City of Albuquerque

**RE: GARY GALBODON OFFICE, LOT 2B, LA MIRADA SUBDIVISION (G19-D14A).
Conceptual GRADING AND DRAINAGE PLAN FOR SITE DEVELOPMENT PLAN
FOR BUILDING PERMIT APPROVAL and Revised G & D PLAN FOR BUILDING
PERMIT. ENGINEER'S STAMP (SEAL) DATED APRIL 2, 2001. Revised PLAN
SEALED APRIL 16, 2001.**

Subject: Galbodon Office Building

GARY GALBODON OFFICE

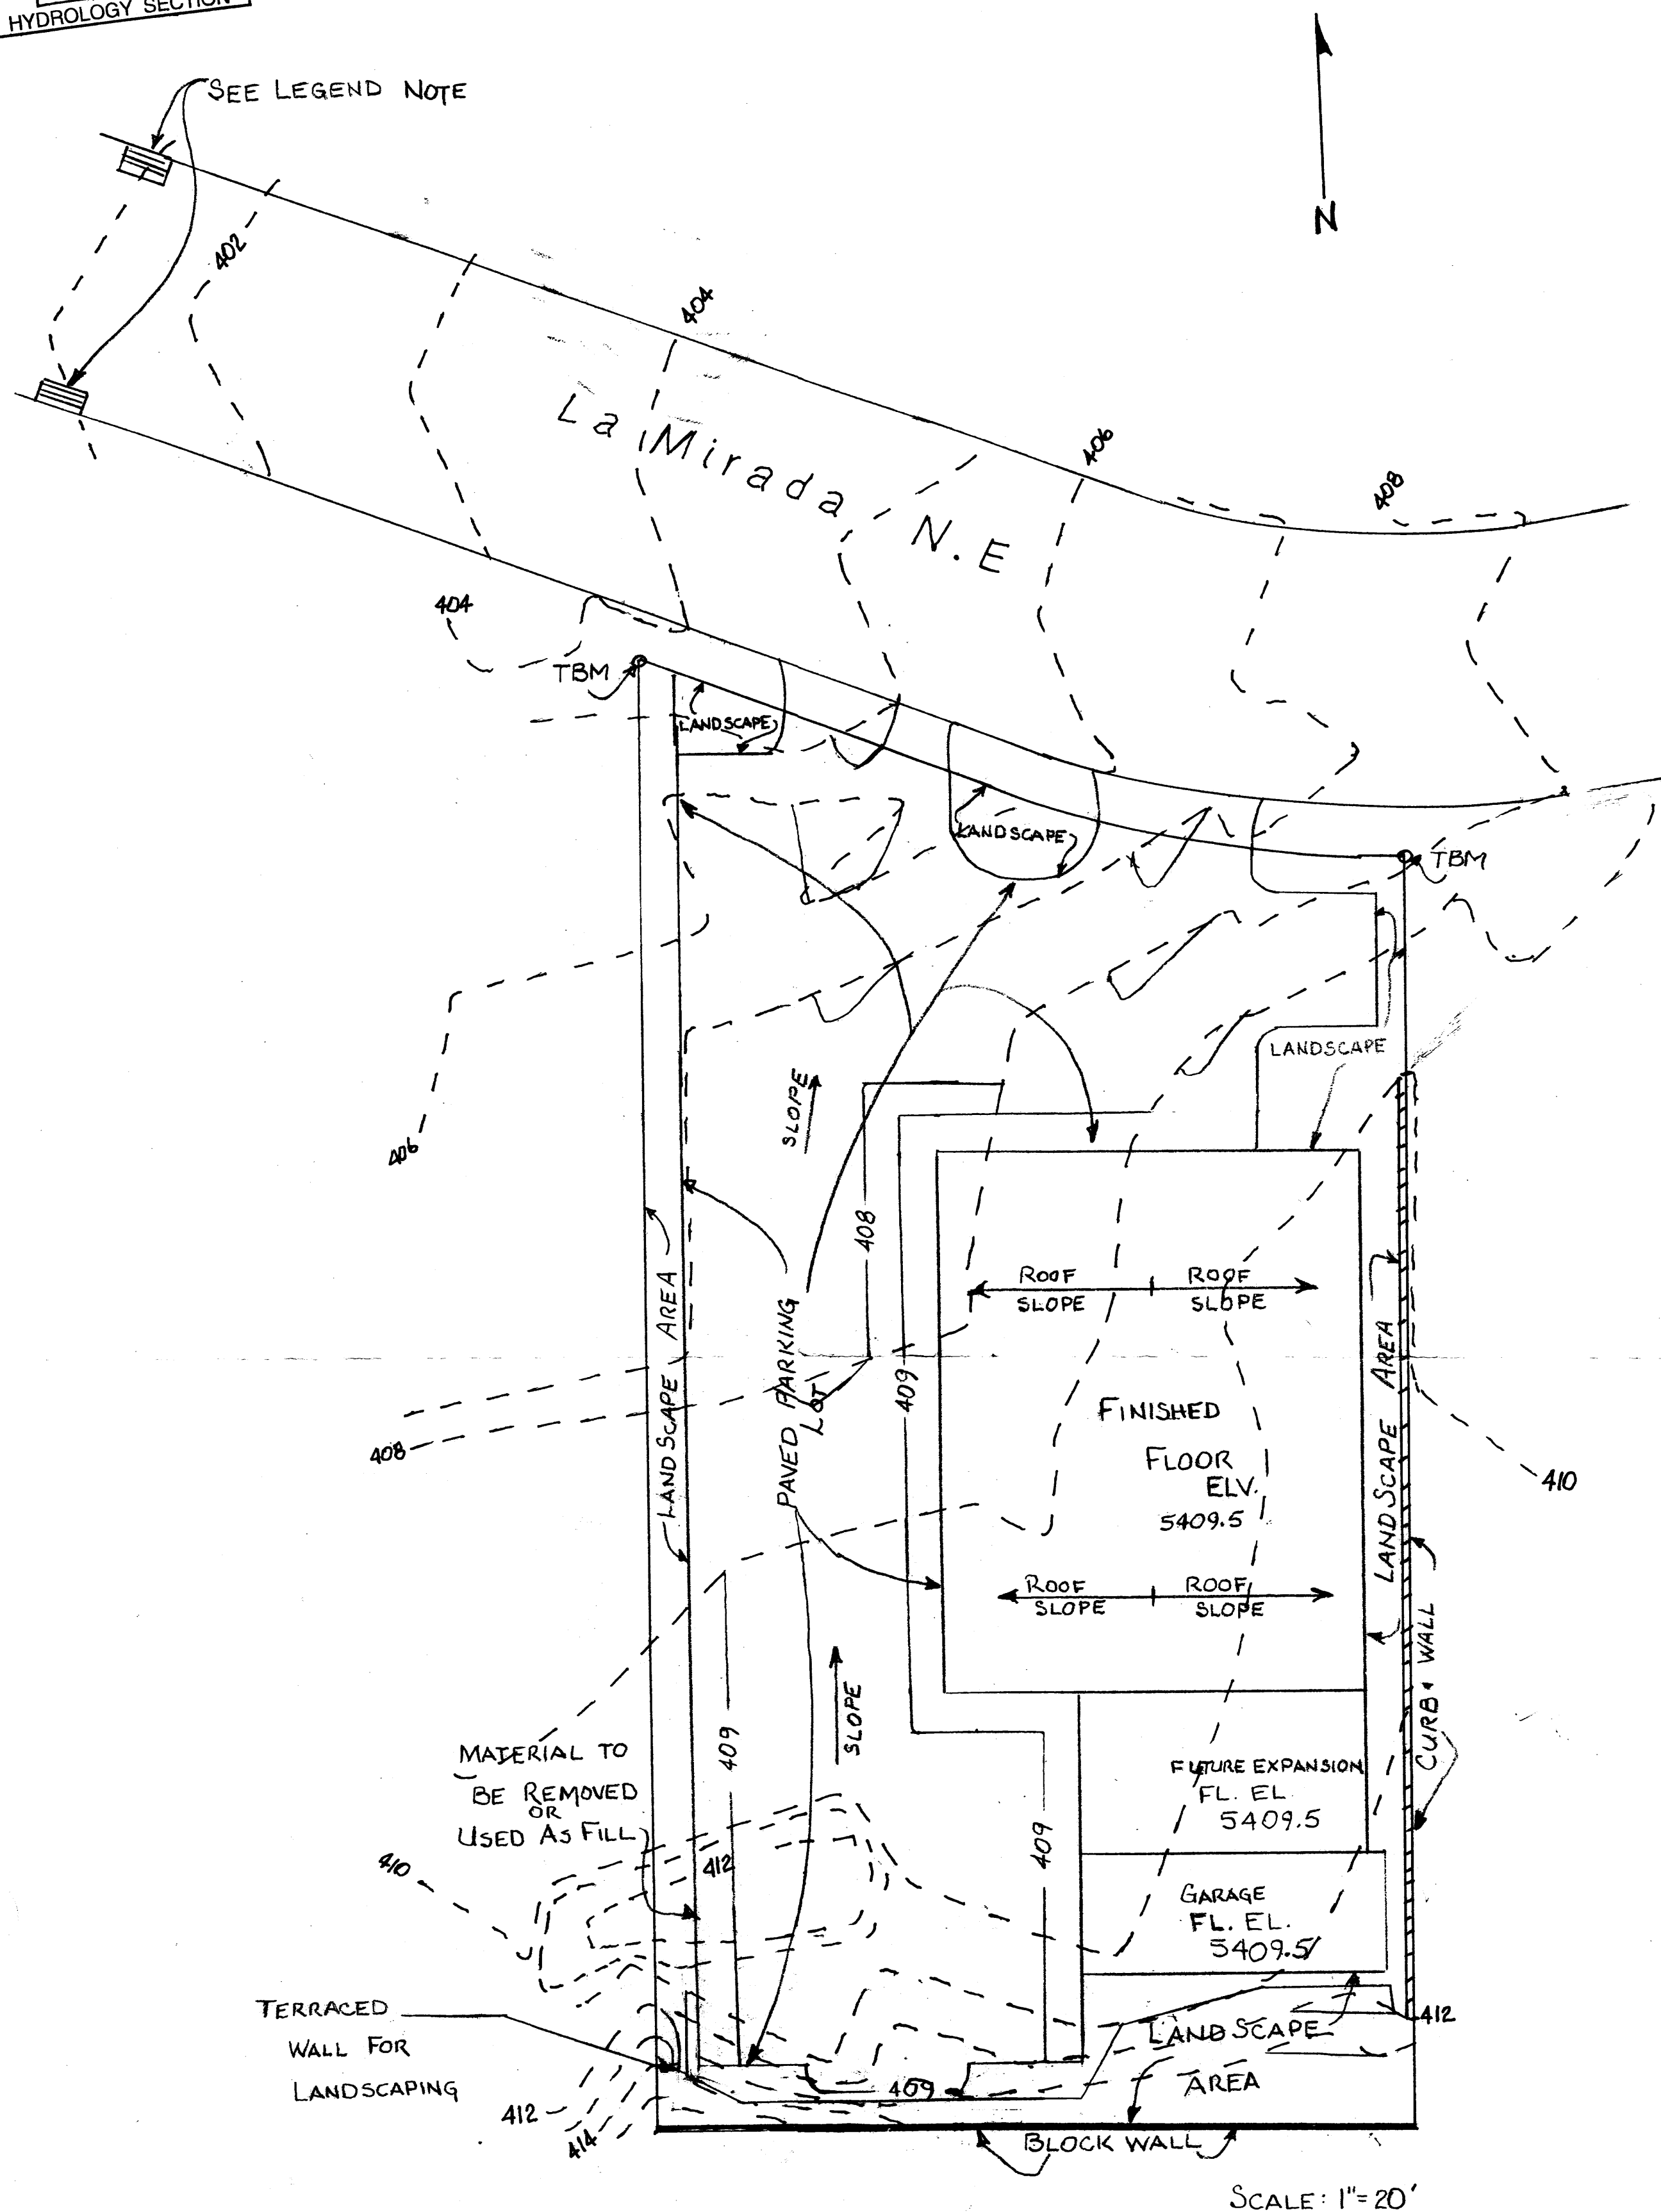
*** Please entitle the Grading and Drainage Plan as such.

- a. Roof drainage directions
- b. Include a reference that each storm drainage opening drains to 42" pipe per discussion with City of Albuquerque Flood Plain Administer.
- c. Added detail for railroad tie retaining wall. Wall to be terraced with no terrace being higher than 3 ft. and that ties will be securely fasten to each other.
